# A14

## Cambridge to Huntingdon improvement scheme

TR010018

HE/A14/EX/03 Summary table of responses to s51 advice and s55 checklist

Drawing title: **LAND PLANS REGULATION 5(2)(i) SHEET 40 OF 40**

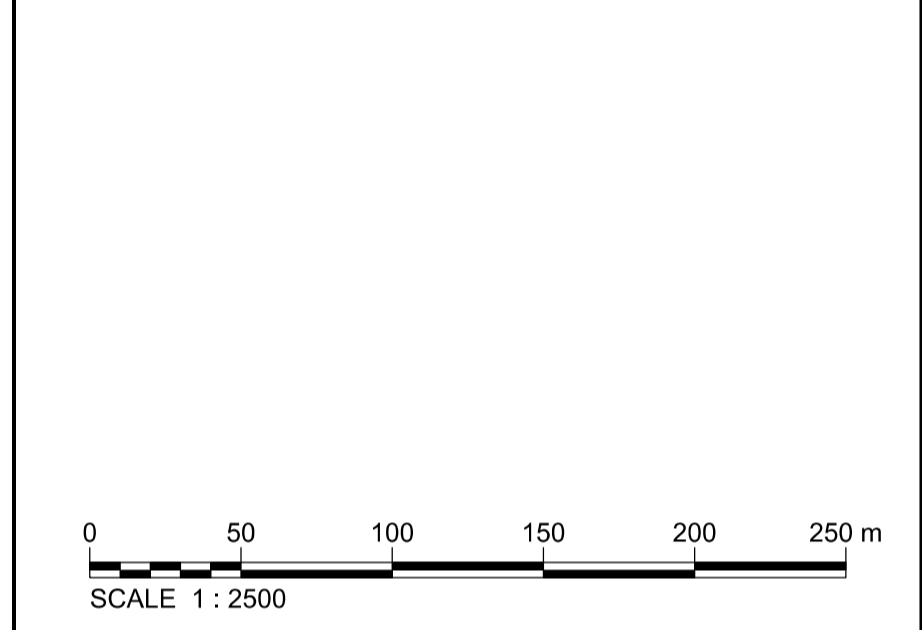
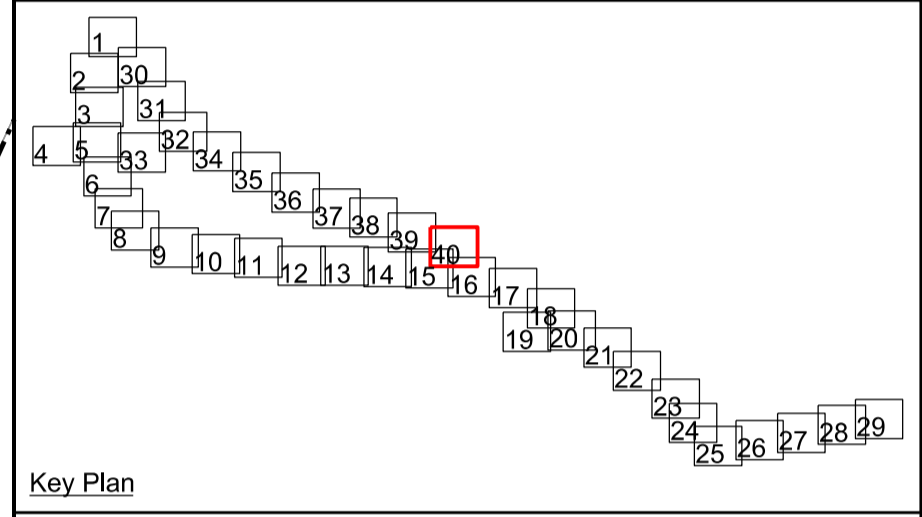
1.15	<i>s55 Checklist: Page 21; 3.3 (i) Land Plan</i>  Plot 17/10d shown on sheet 17 is not listed in the Book of Reference. It is difficult to determine the extent of Plots 26/16 – 26/19, 26/22, 26/27 and 26/29 – 26/31 at the submitted scale.	Plot number 17/10d is included in the updated Book of Reference (Document Reference HE/A14/EX/03), submitted on 26th March 2015.  As explained in response 1.14 above 'For clarity 'Inset C' has been added to the updated Land Plans Sheet 26 of 40 to include labels for plots 26/16 to 26/19, 26/22 to 26/24, and labels for plots 22/1e, 22/1h, 22/1k, 22/1o, 22/25, 26/27 and 26/29 to 26/31 have been added to 'Inset B'.'	HA/A14/EX/03  HA/A14/EX/08
<b>Statutory consultees</b>

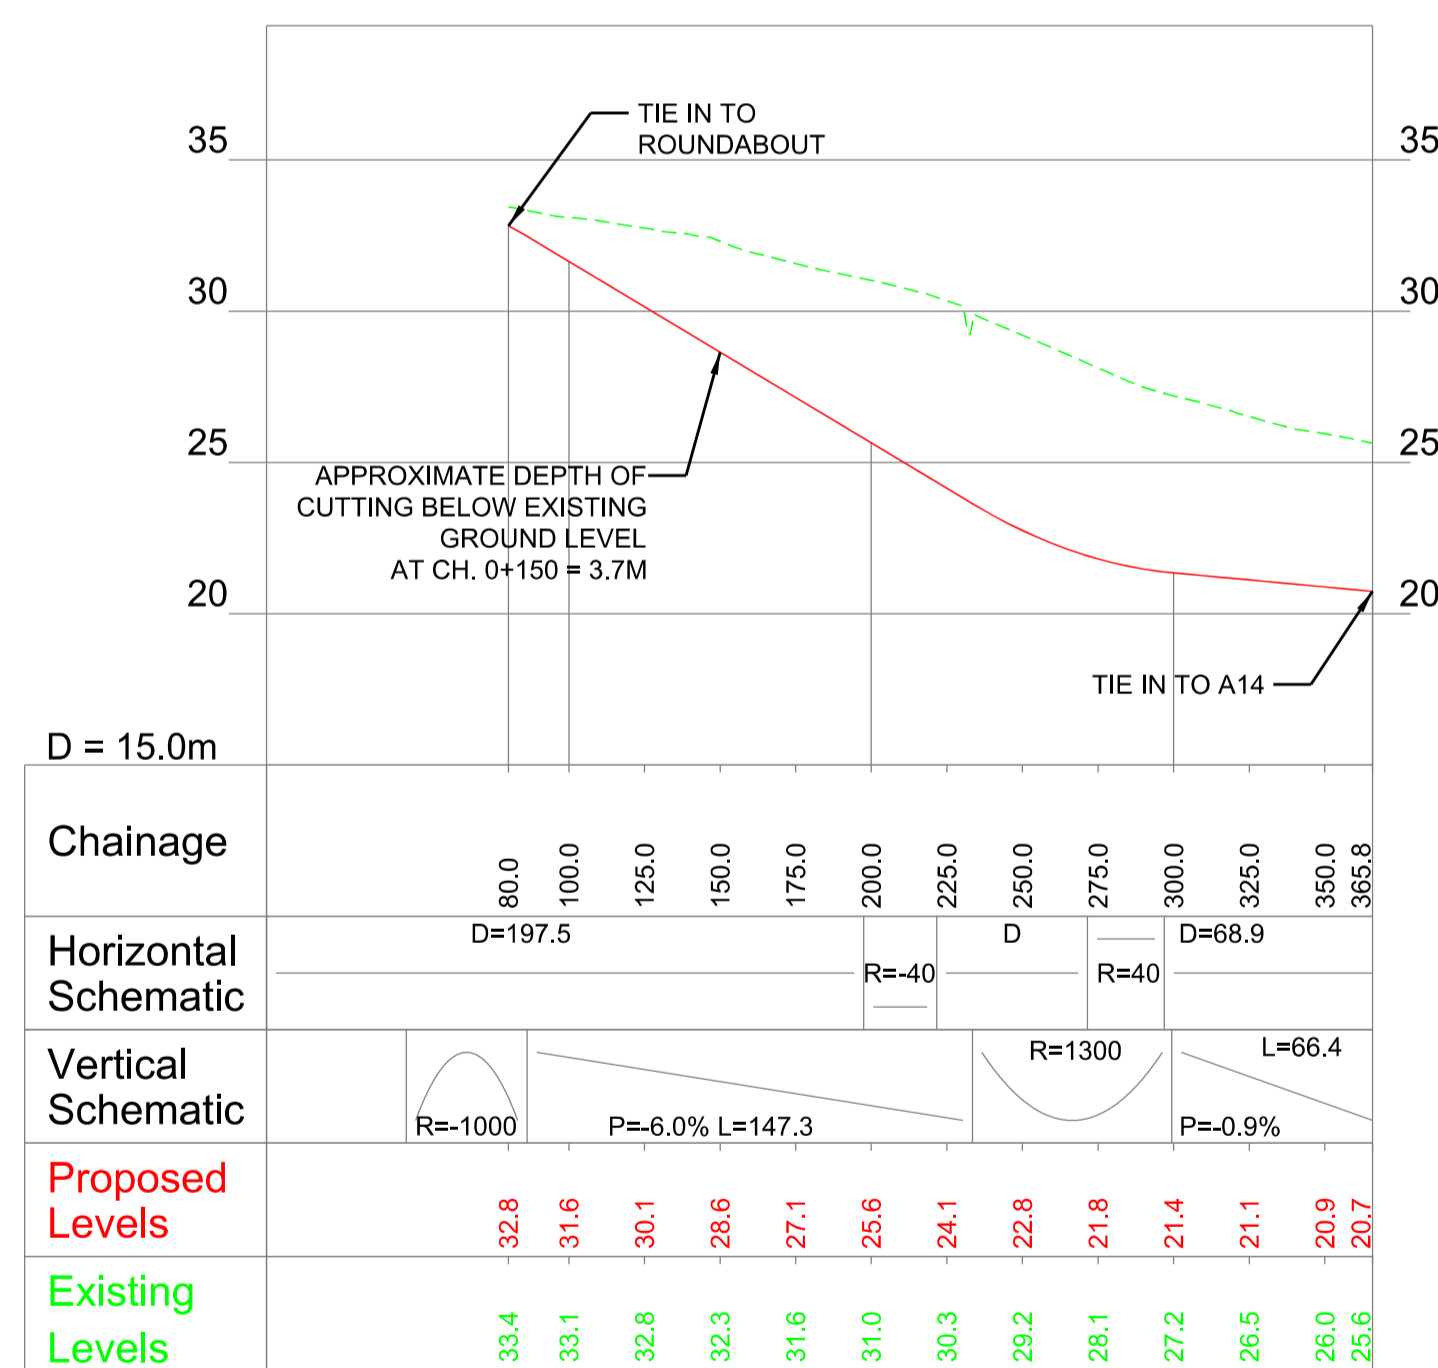
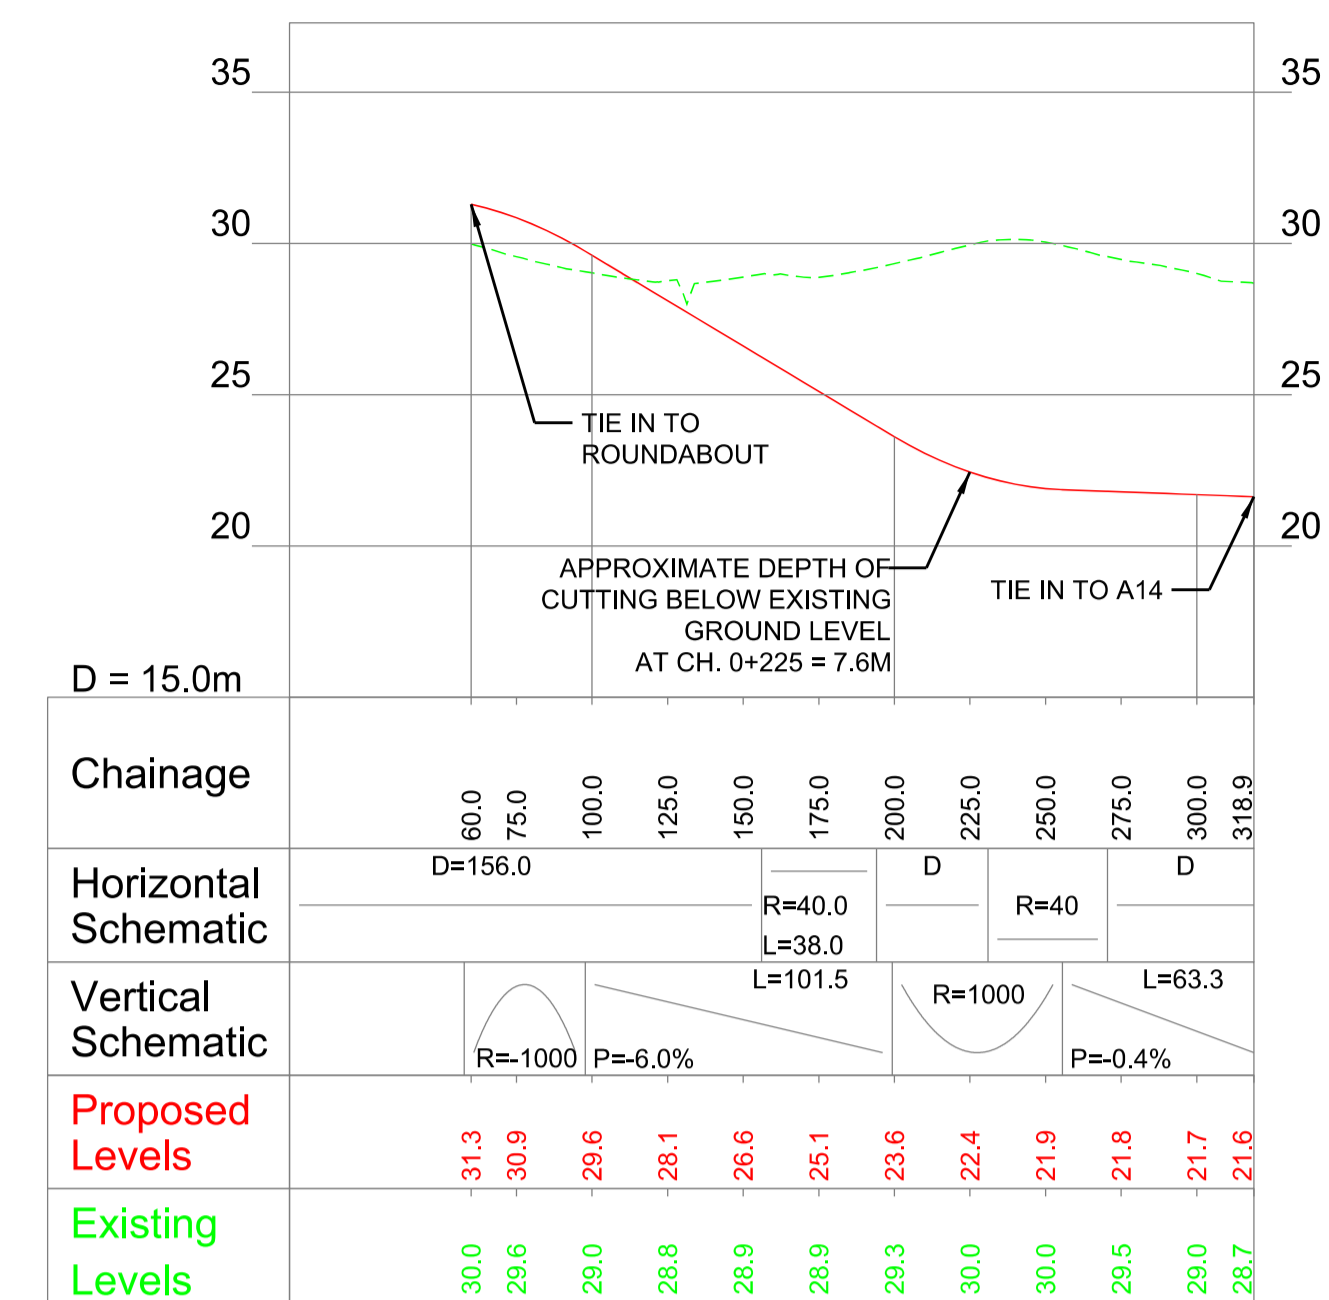
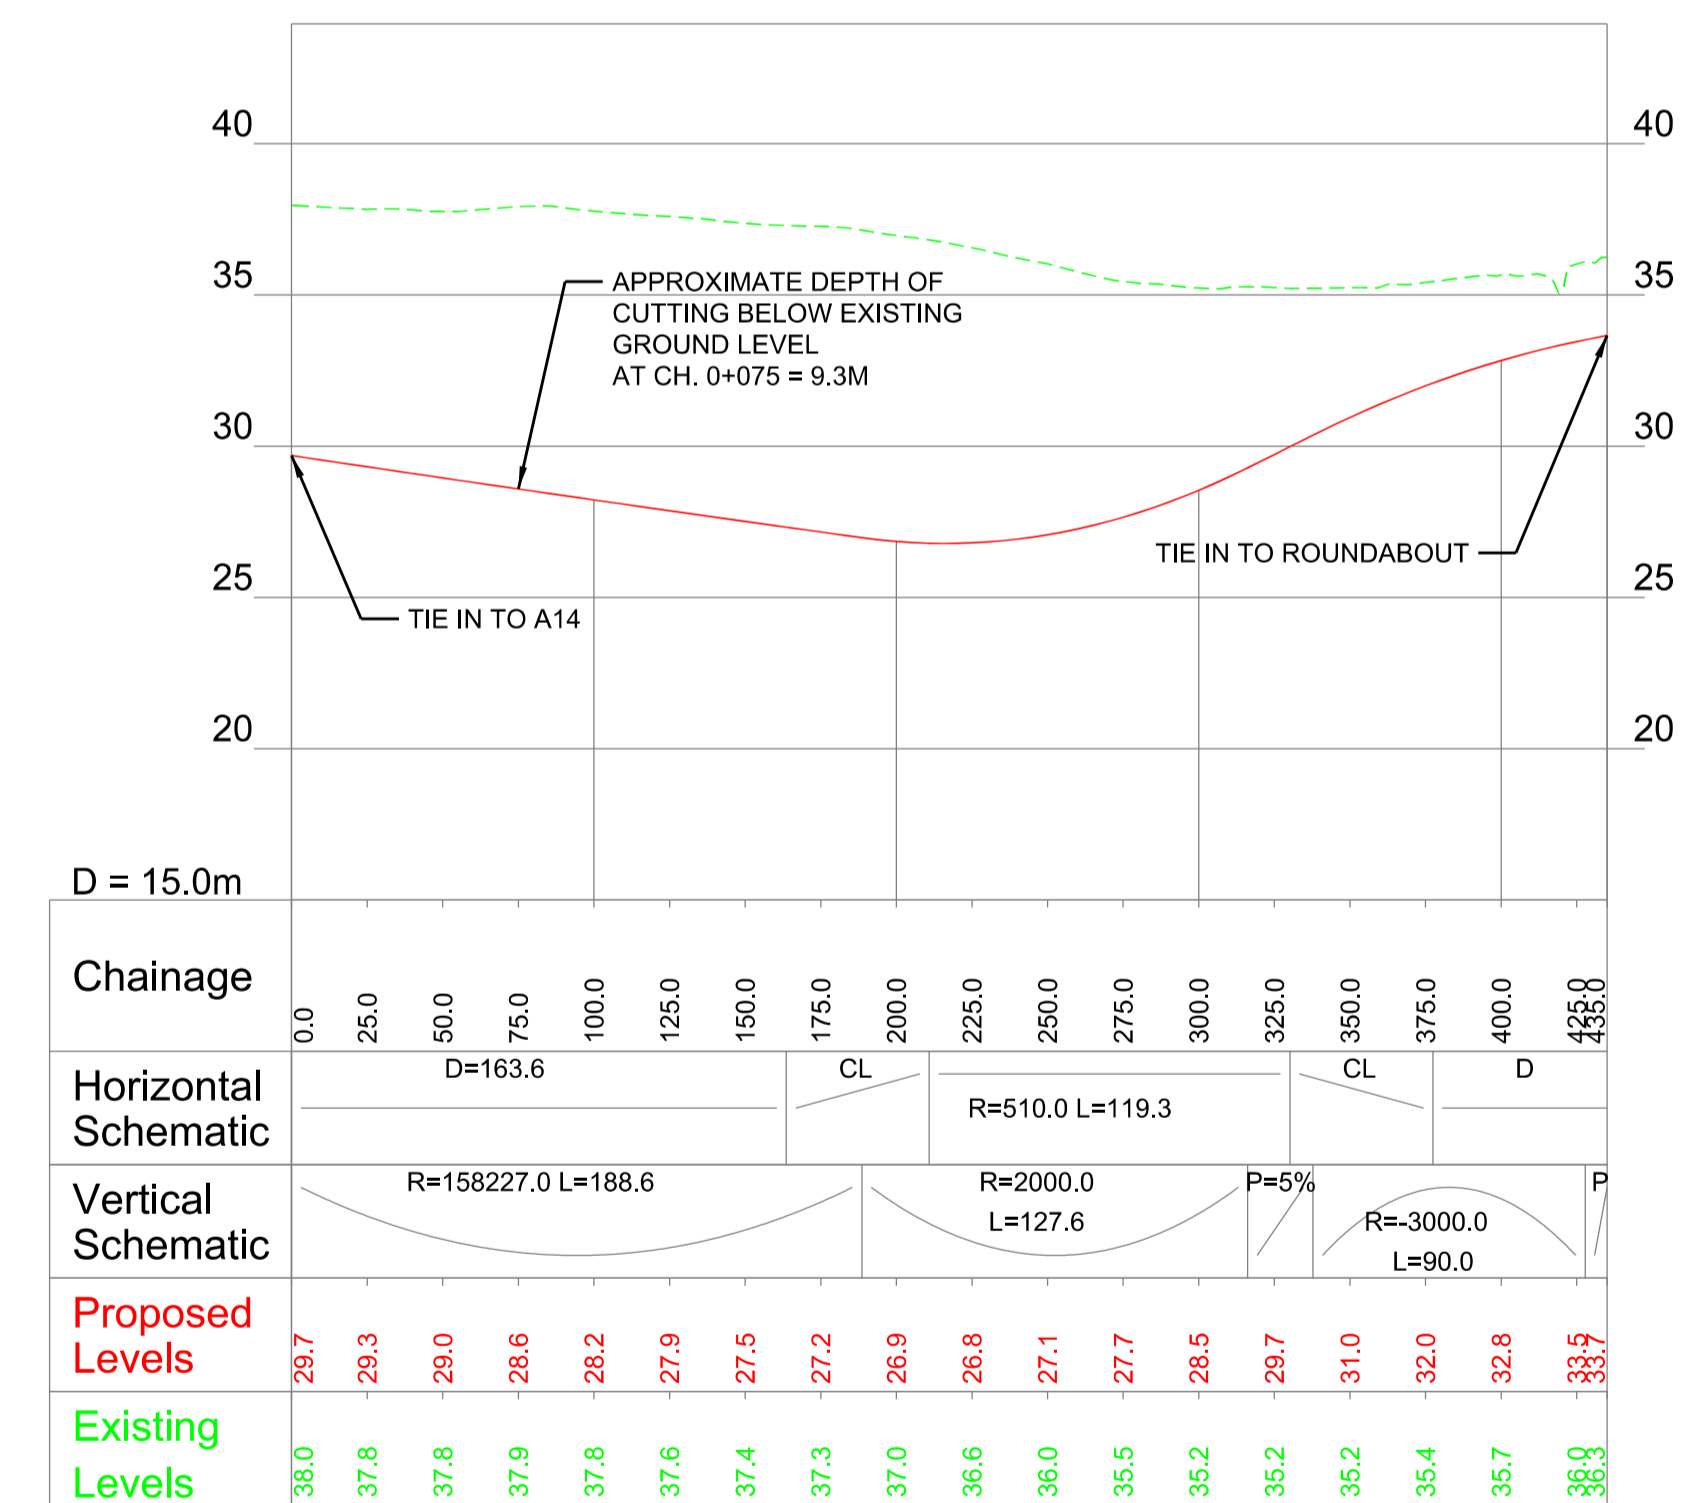
1.10	<p><i>s55 Checklist: Page 25; 3.3 (p)</i></p> <p>There are a number of labelling errors which present a barrier to comprehension:</p> <ul style="list-style-type: none"> <li>• A14 Mainline (sheet 3) – transverse A1 labelled as A14</li> <li>• A1 to A14 Westbound interchange link (sheet 9) – transverse A1 labelled as A14</li> <li>• A14 Eastbound Maintenance Offslip (sheet 14) – onslip labelled as offslip</li> <li>• A1198 Ermine Street North Roundabout Link (sheet 12) – should state that it links north and south roundabouts</li> <li>• Westbound Diverge slip Road (sheet 14) – Emergency maintenance access labelled as diverge slip road</li> <li>• Bar Hill Junction Services Access (sheet 22) – northwestbound merge labelled as northeastbound merge</li> </ul>	<p>The labelling errors identified have been corrected in the updated Sheets, provided in Document Reference HE/A14/EX/07:</p> <ul style="list-style-type: none"> <li>• Sheet 3 is still Sheet 3 in the updated set</li> <li>• Sheet 9 is Sheet 17 in the updated set</li> <li>• Sheet 14 is Sheet 21 in the updated set</li> <li>• Sheet 12 is Sheet 22 in the updated set</li> <li>• Sheet 14 is Sheet 21 in the updated set</li> <li>• Sheet 22 is Sheet 31 in the updated set</li> </ul>	HE/A14/EX/07
